## SITE DEVELOPMENT PLAN CHECKLIST

PPR2140 - Rocky Top

Revised: October 2023

SIGNAGE PLAN
 ROCKY TOP MOTEL & CAMPGROUND
 JOB NO. 25133.00
 11/1/21
 SHEET 1 OF 1

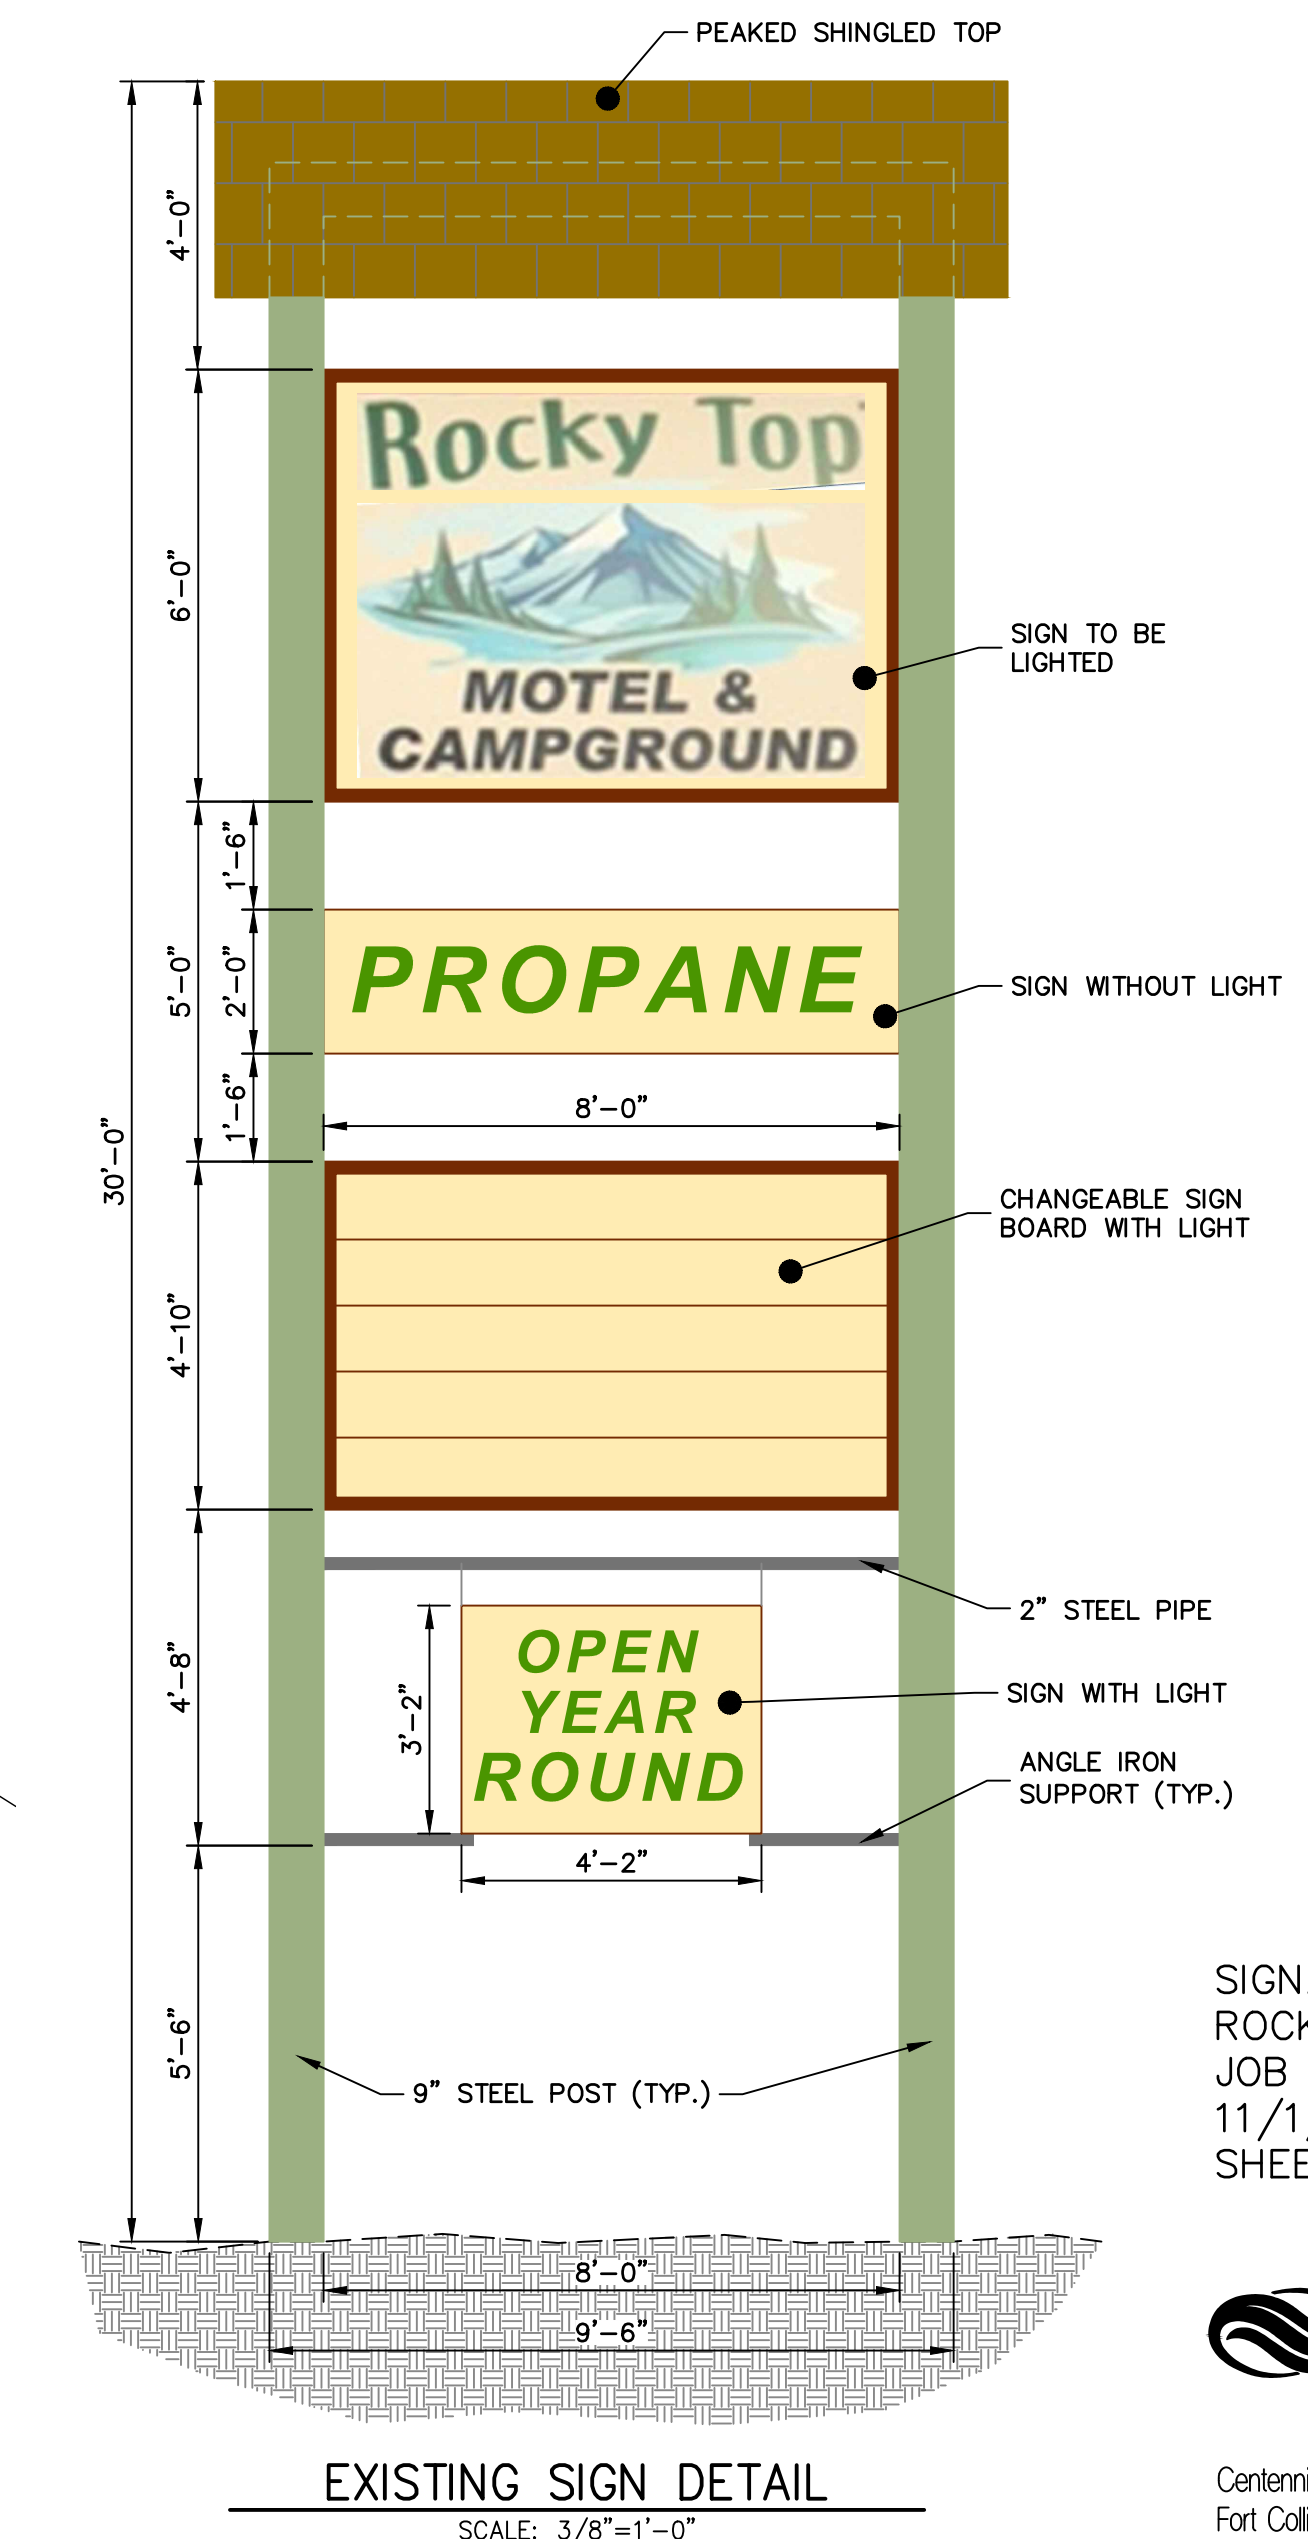
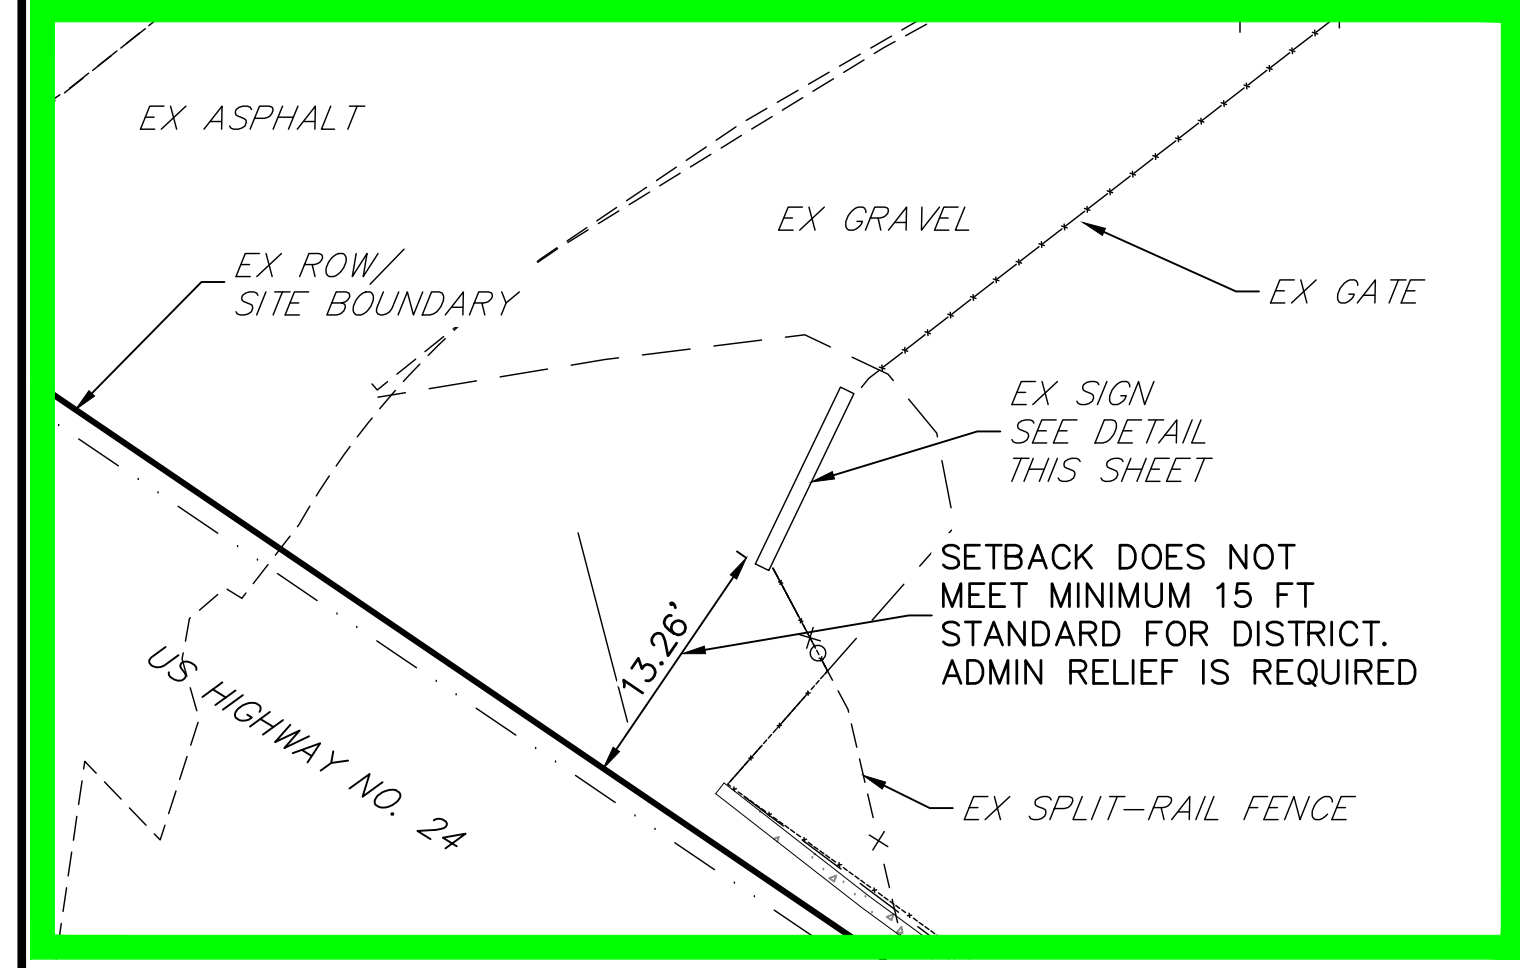
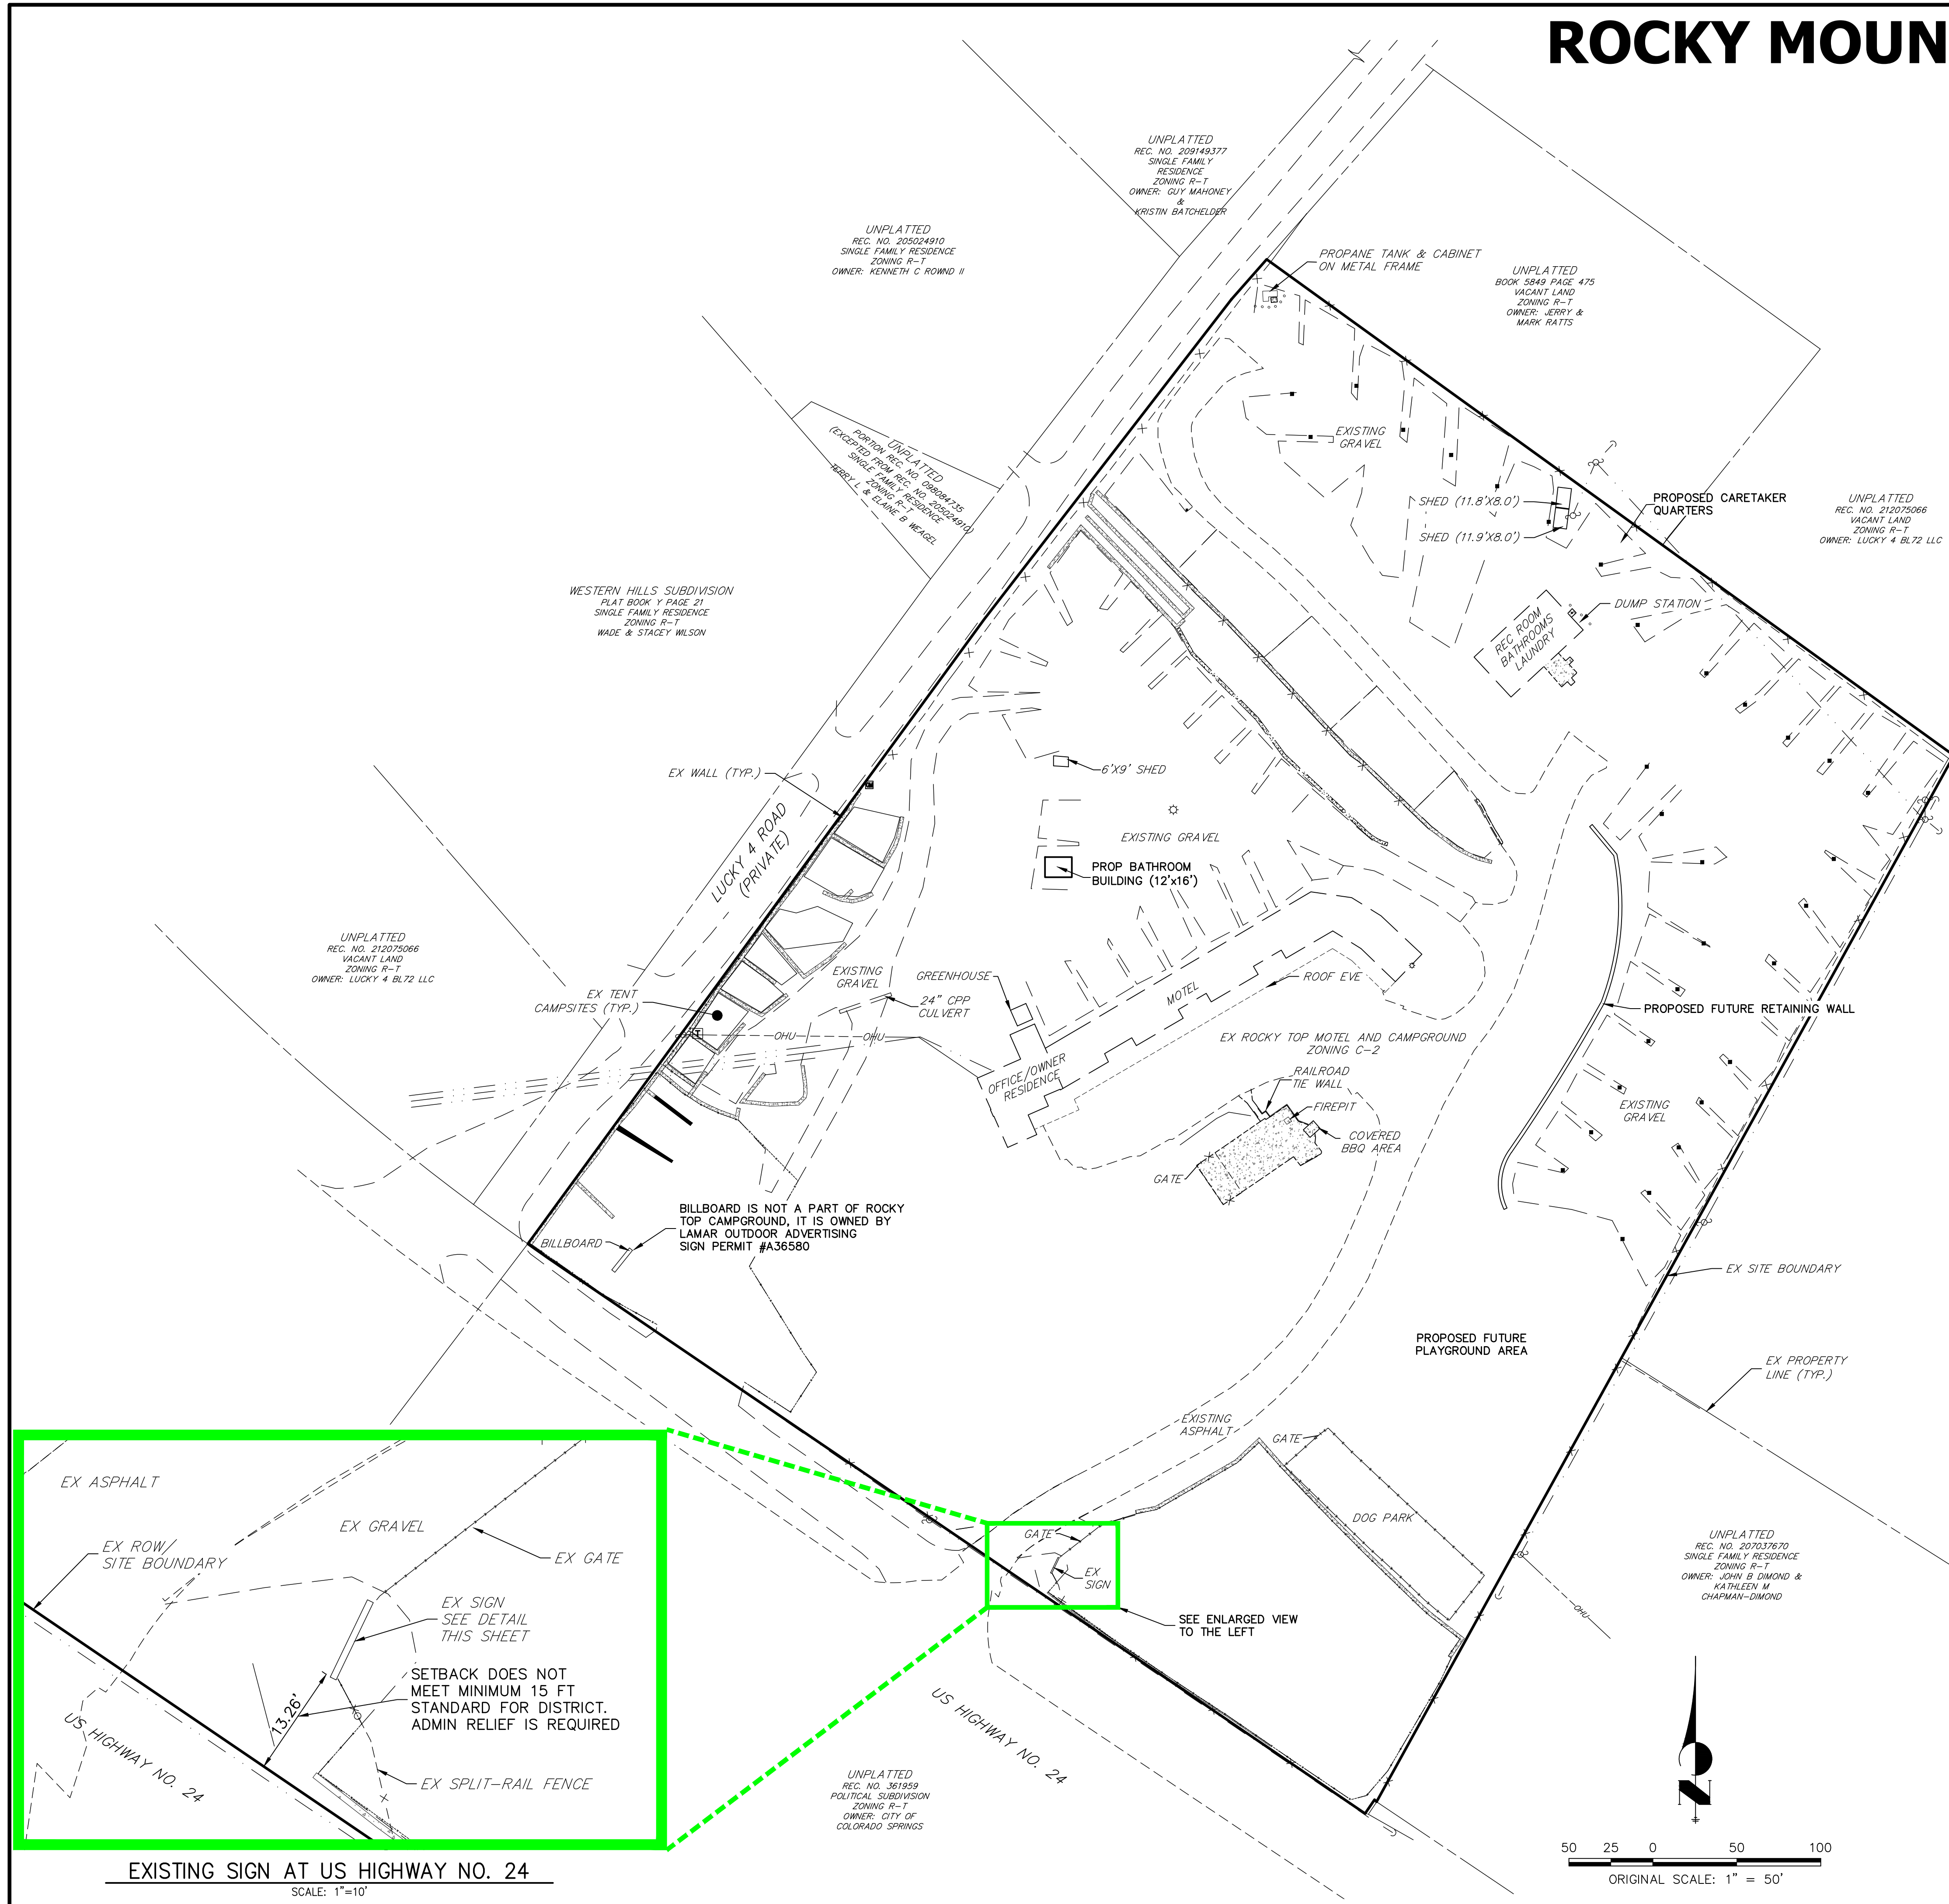
- ☐ Location and dimensions of all existing and proposed signage on site 1/2 shown → east sign by entrance. ADIR approved needs SC-
- ☐ Traffic circulation on site including all points of ingress/egress into the property → identify asphalt pavement, gravel, width, grade (legend)
